LAND TECHNOLOGIES, INC.

Response to Comments

Project Name: Ideal Industrial Park
 Project File Number: PA23010
 Review Completion: July 20, 2023

SHEET: **A1.0**

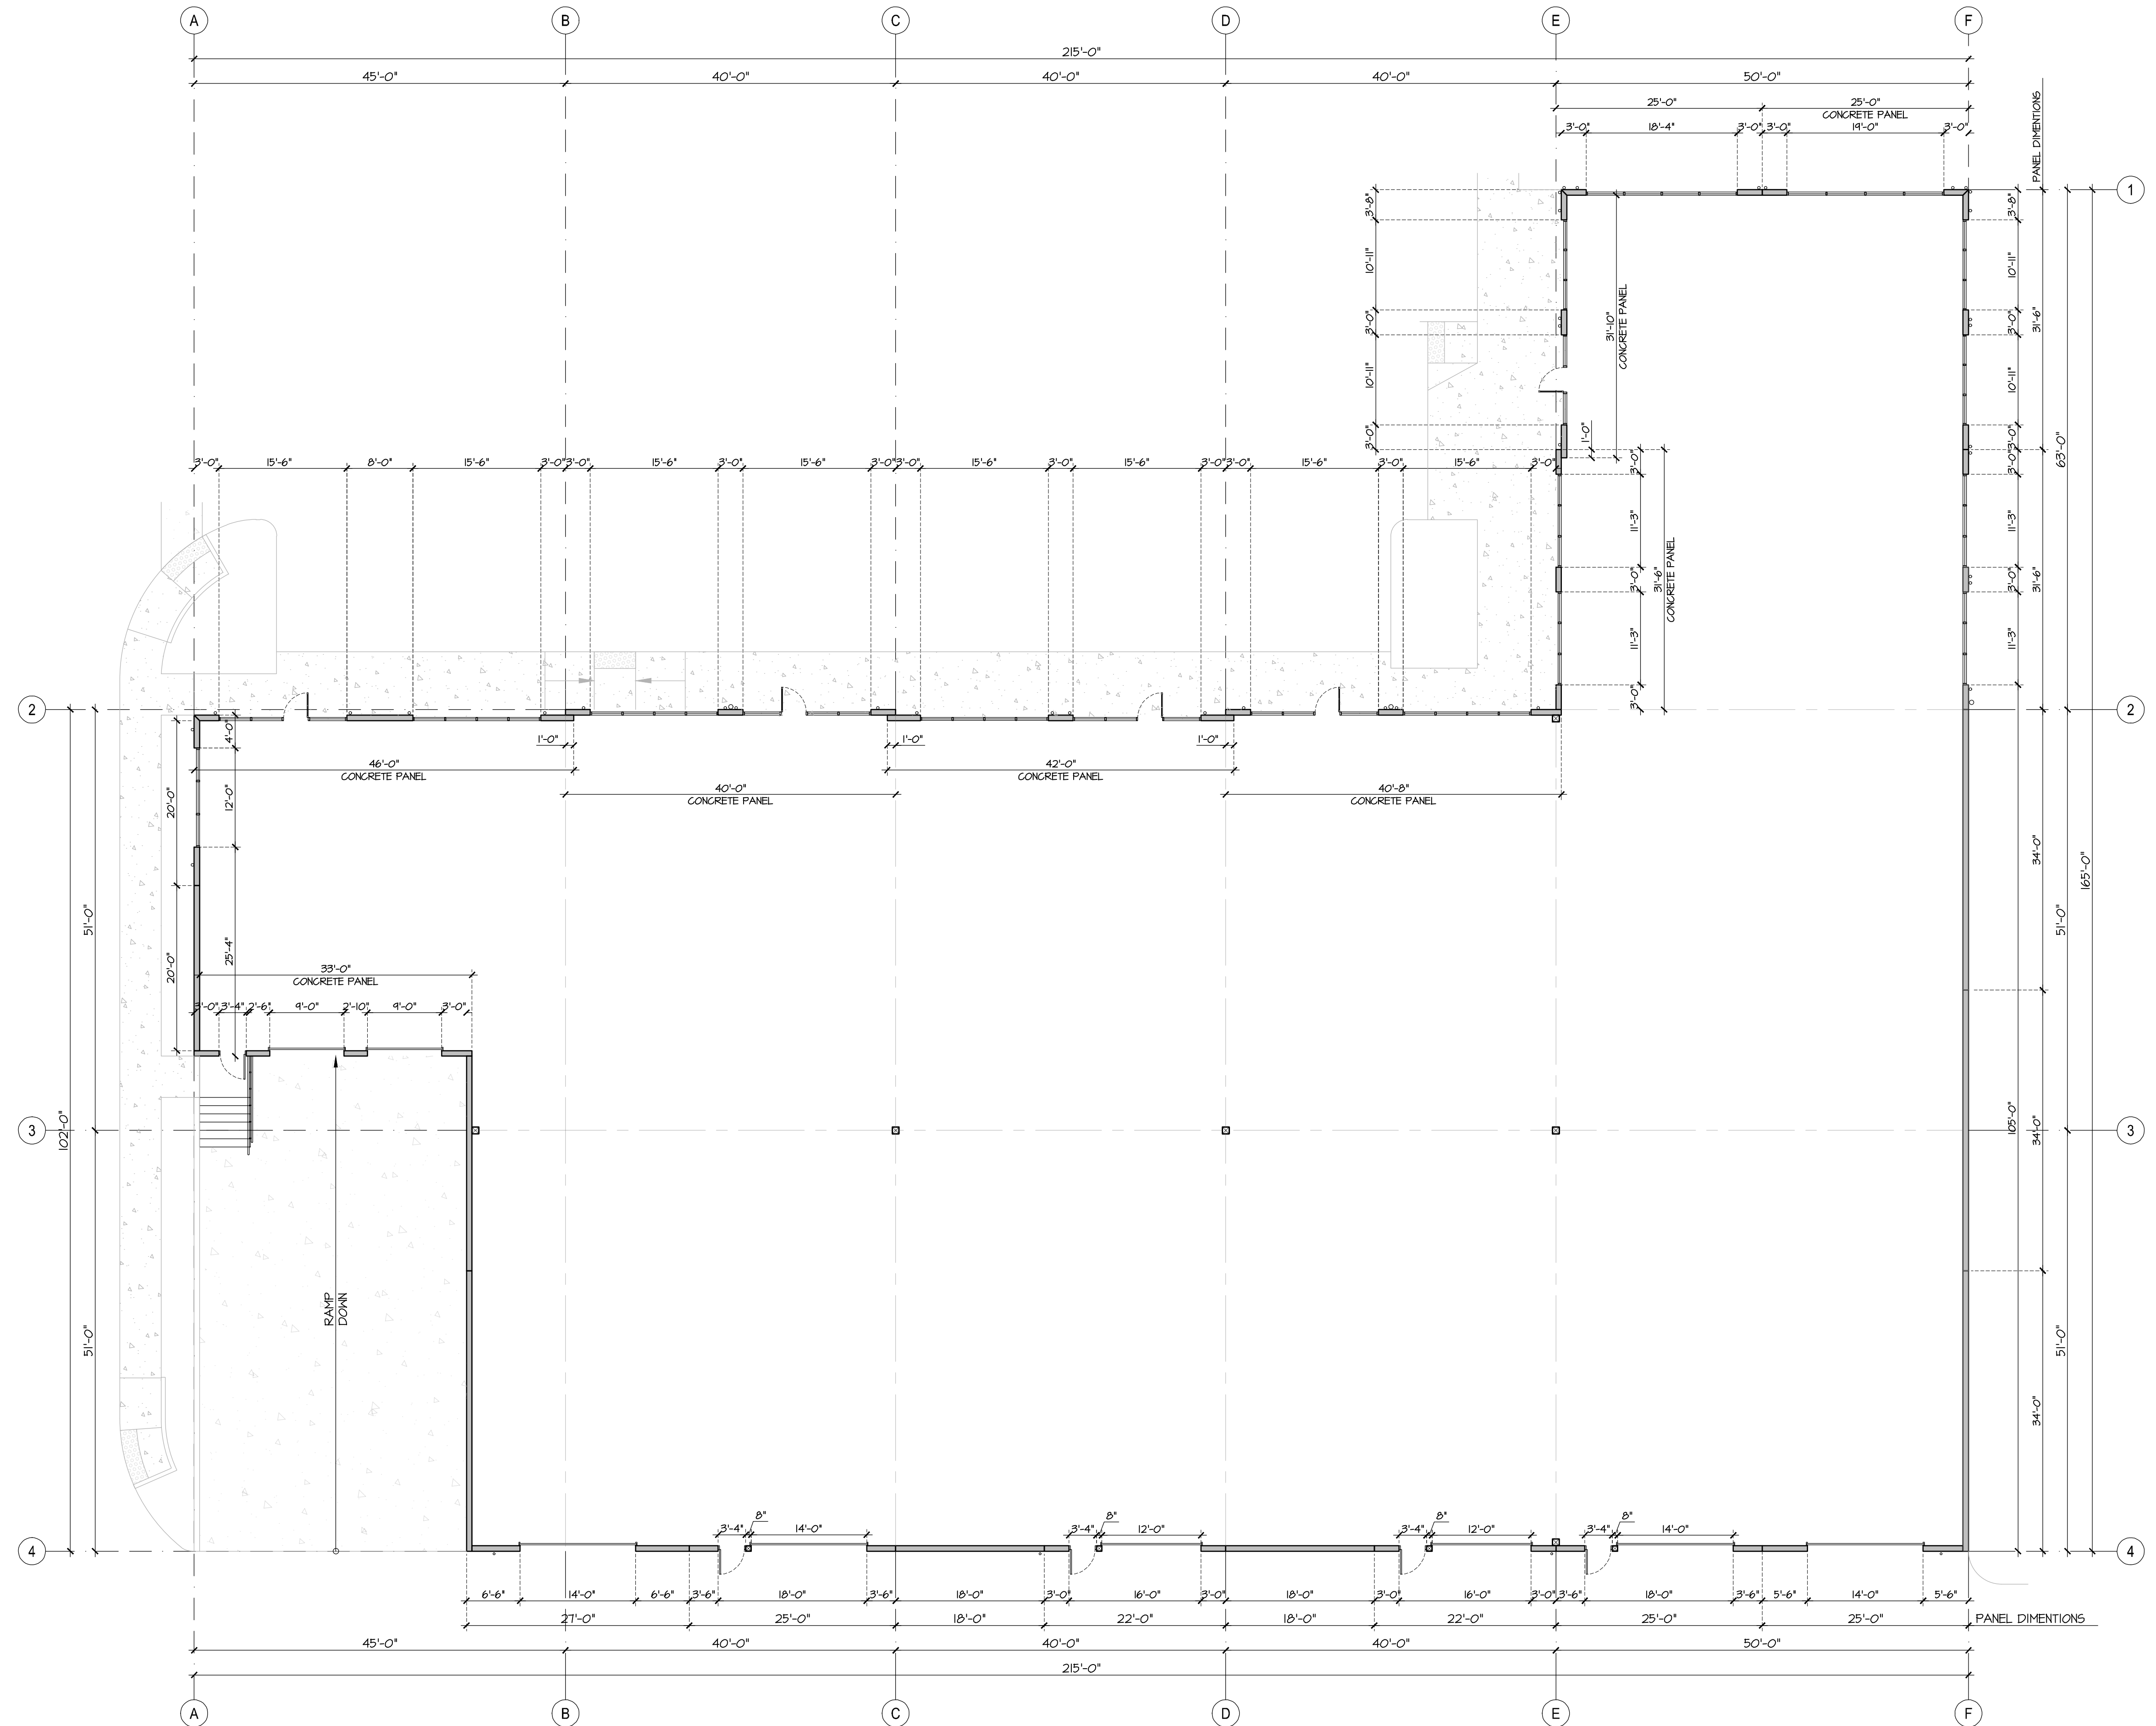
CITY COMMENTS	LAND TECH RESPONSE
<p>4. Sheet P1 shall be amended as follows:</p> <ul style="list-style-type: none"> a. The minimum parking stall depth shall be 18' (16' proposed). A 2' overhang is not allowed adjacent to a public sidewalk. A 2' overhang is allowed adjacent to landscaped areas. b. Ten (10) bicycle stalls shall be provided (4 proposed). c. The proposed pedestrian pathways traversing the parking areas shall be constructed with decorative concrete and not striped. d. Amend Note to read: "Per MMC 22C.020.340(2) any mechanical. . e. Amend Notes to include all of the following: <ul style="list-style-type: none"> . Where illuminated signs and illuminated areas are permitted, such illuminating devices shall be shaded and/or directed so as not to visibly create a nuisance to any property in a residential zone classification. Residential zoning is located to the east of the proposed development. . Mechanical equipment located on the roof, facade or external portions of a building shall be architecturally screened so as not to be visible from adjacent properties at street level or the public street. . Equipment or vents which generate noise or air emissions shall be located on the opposite 	<p>See Response in LMA Response Letter.</p> <ul style="list-style-type: none"> a. Building A and B are provided with 7-ft sidewalk and 16-ft stalls as detailed. Building C has 18-ft stalls and 5-ft sidewalk. A second parking detail will be added to show this configuration for Building C. b. Table will be updated to 10-stalls. c. Note added to Sheet P1. d. Note has been updated to 22C. e. Notes are updated/added.

FLOOR PLAN - BUILDING A
SCALE: 3/32" = 1'-0"

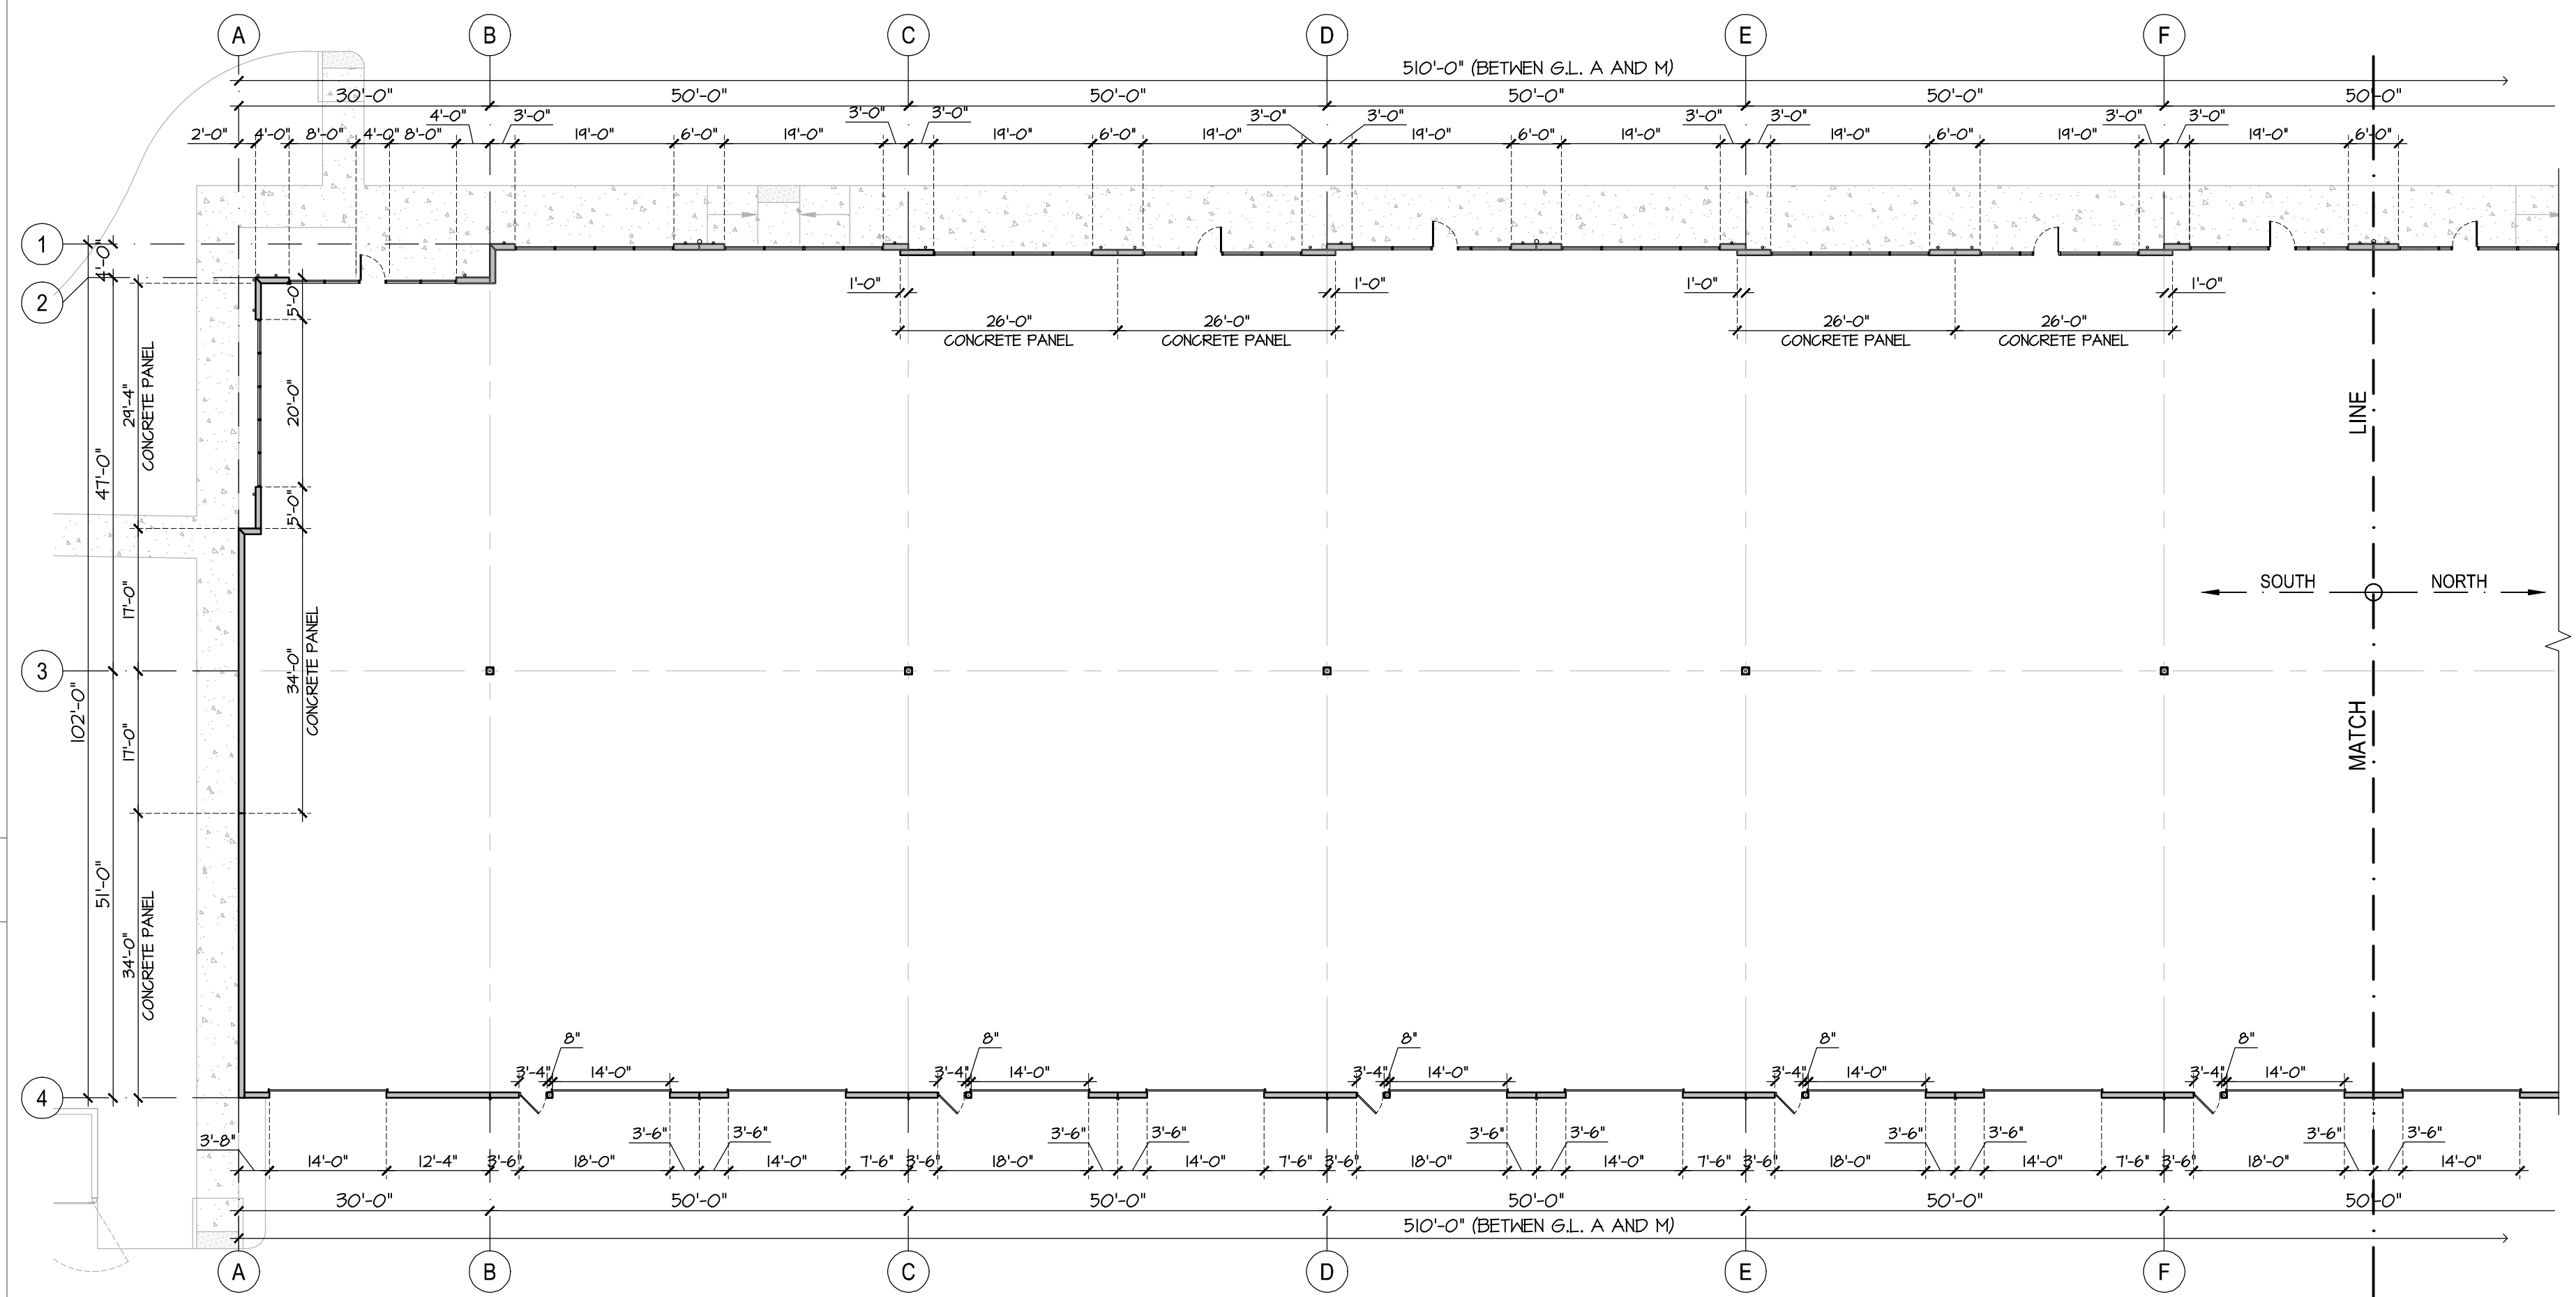
40. The Civil plan does not show the riser rooms or FDC's for building 1 and 2. Access and hydrant placements appear acceptable. FDC's for building 1 and 2 will have to be located within 3-10 feet from a hvdrant and shown on the civil plan additional hvdnants may be needed.	Riser rooms for Buildings A and B have been added. FDC, hydrants are located at the immediate entrance, as close to buildings as possible, in effort to expedite emergency service.
